**Pitt Street North OSD Request for Additional Information  
Stage 1 Modification (SSD 8875 MOD 1) & Stage 2 (SSD 10375)**

I refer to the above applications for the Pitt Street North OSD. The Department requests that you provide additional information on the following:

Envelope Protrusions - Typical Tower levels

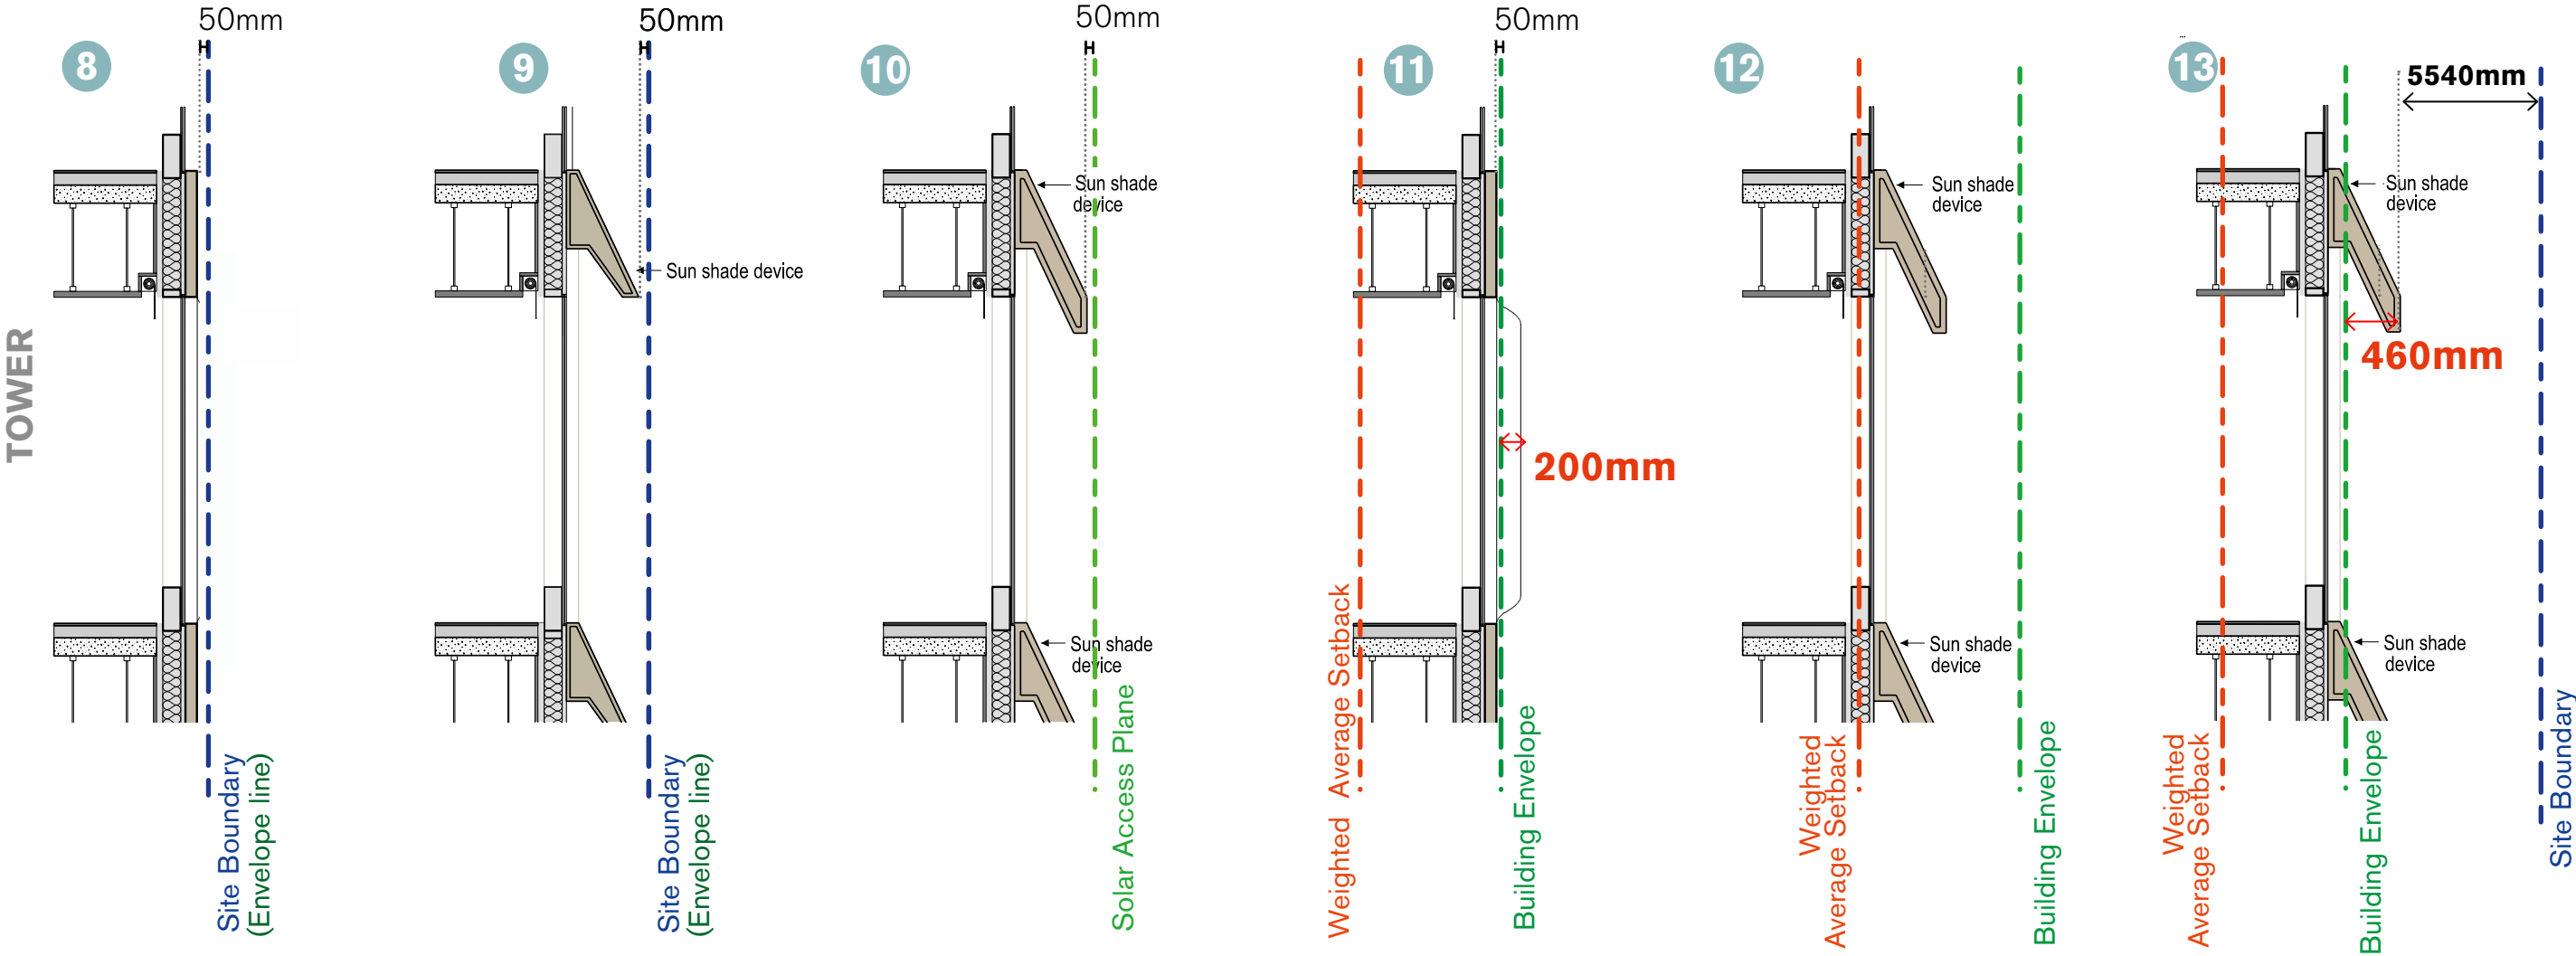
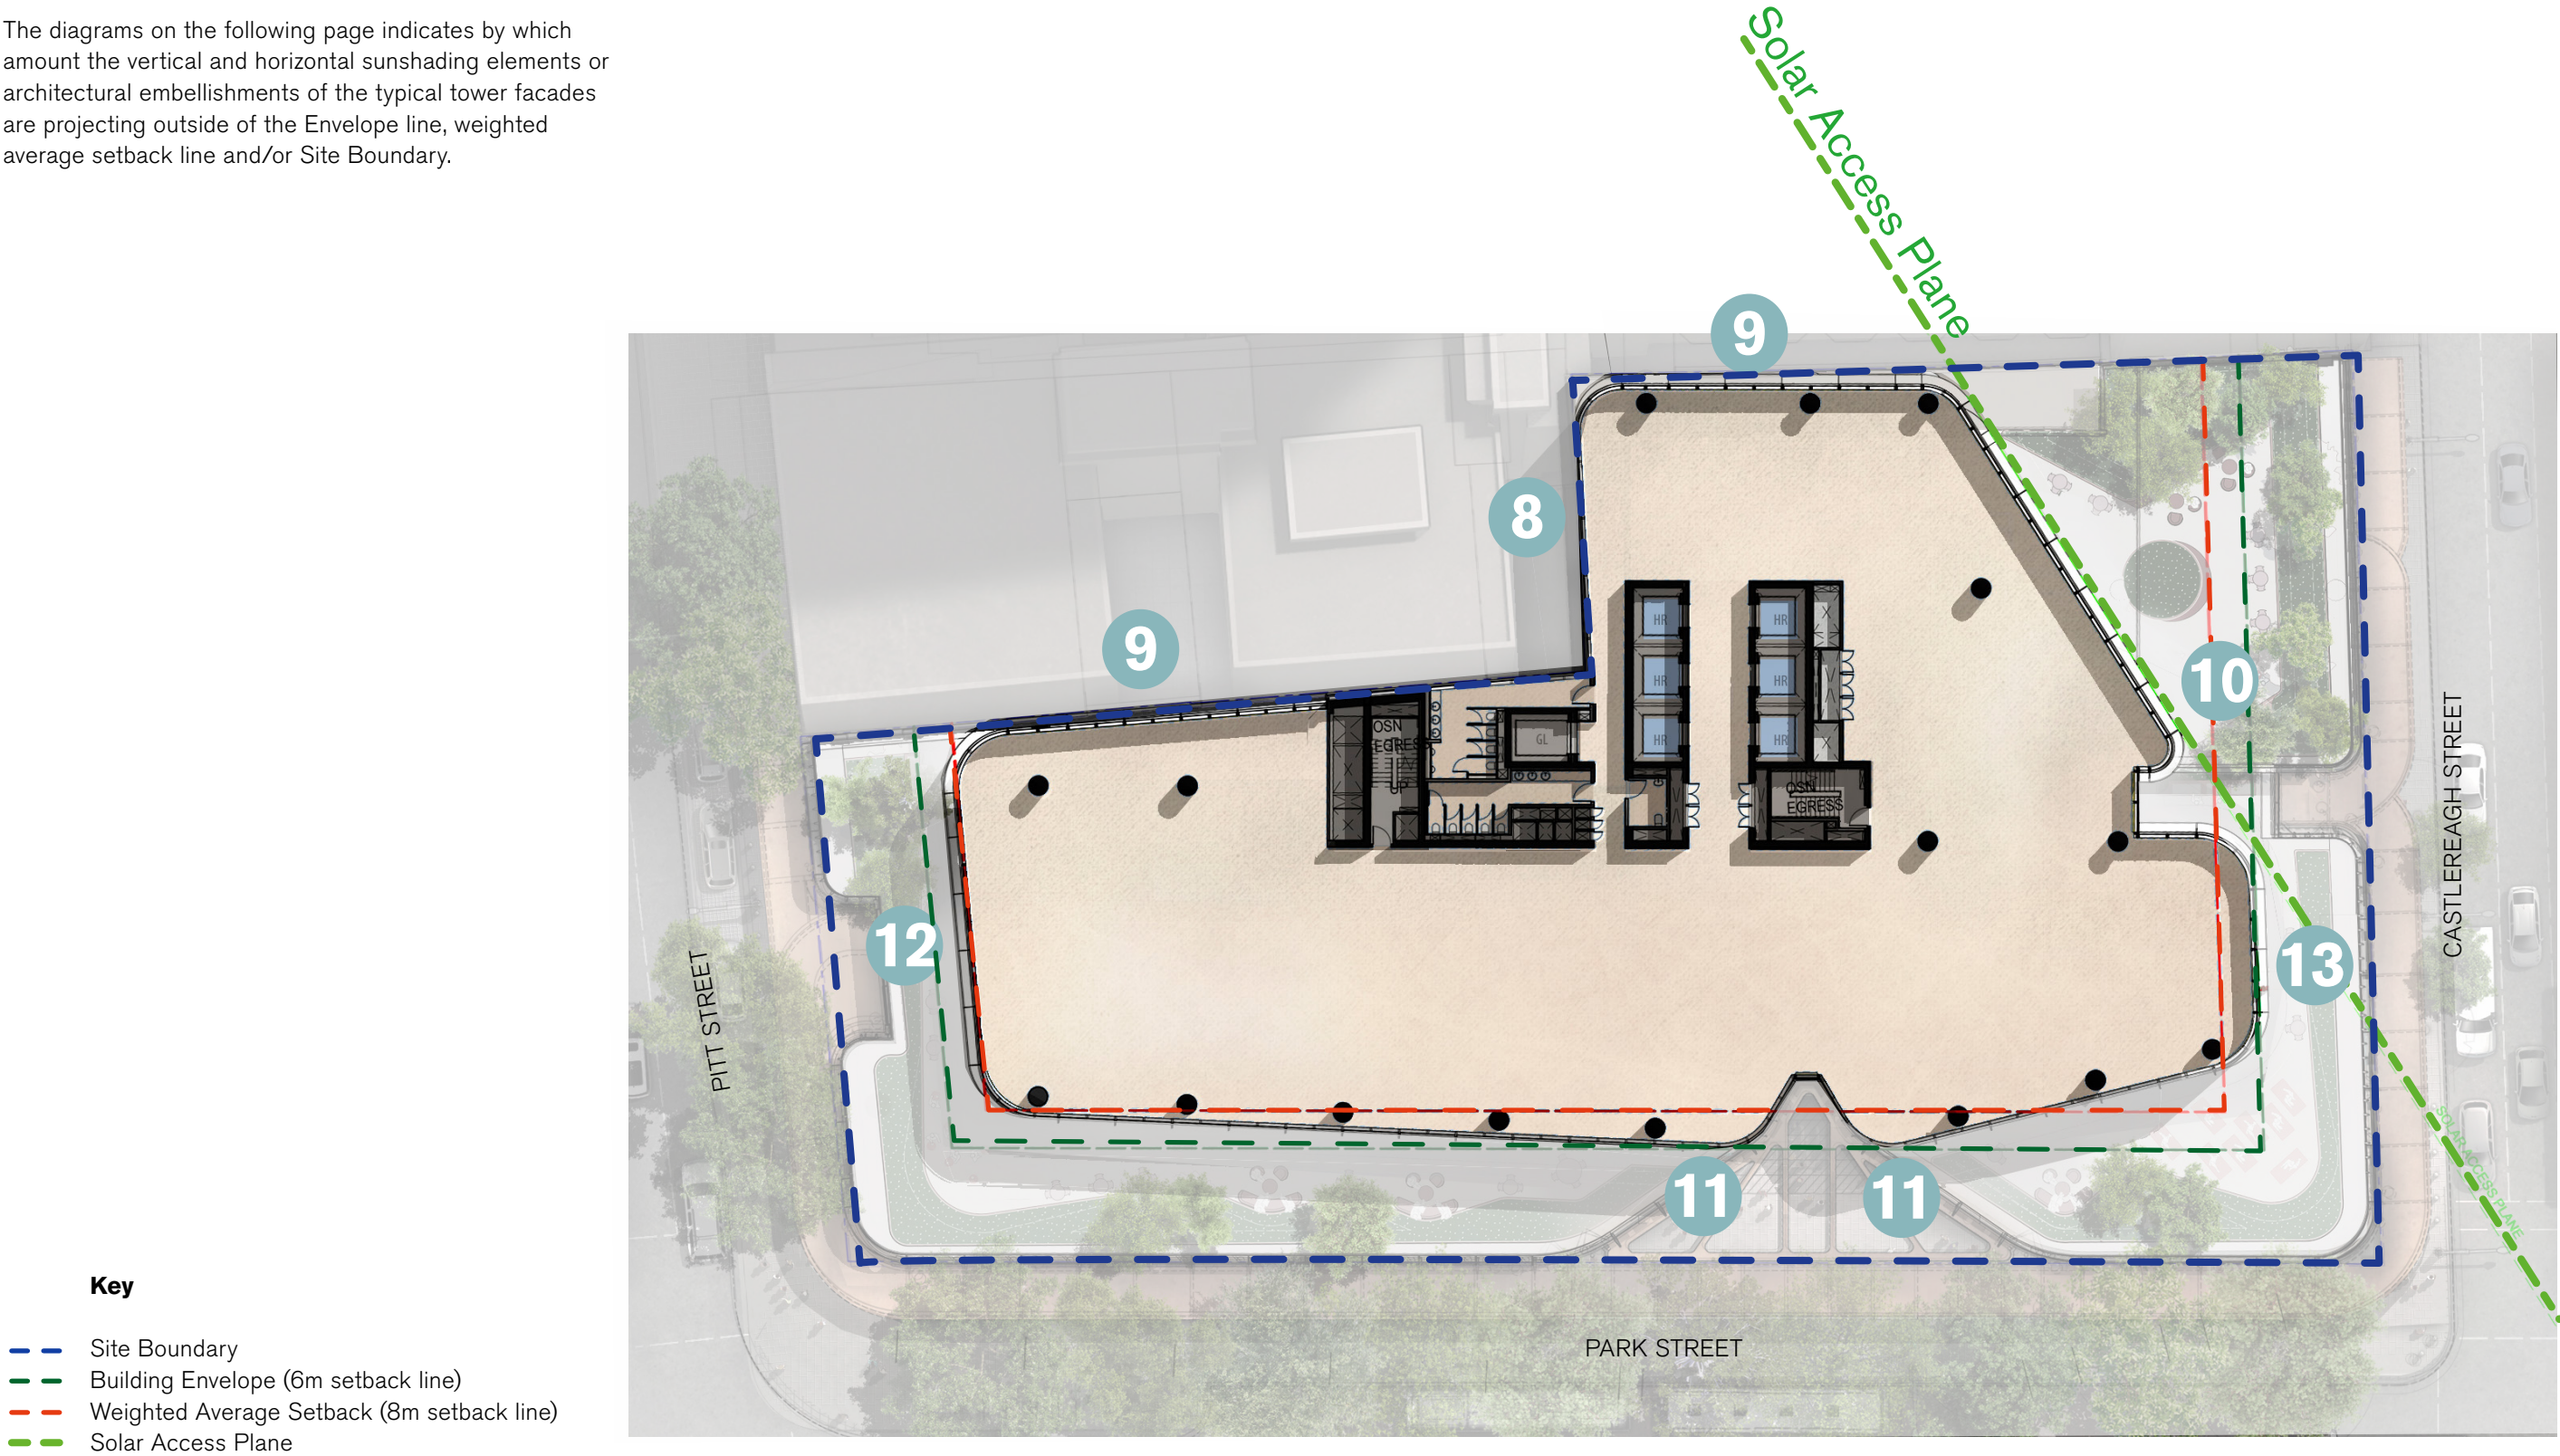
- Clarify the extent of the proposed projections beyond the approved building envelope. In particular, the extent (if any) of the proposed sunshades on the tower encroaching on the required minimum 6 metre setback along Castlereagh Street.
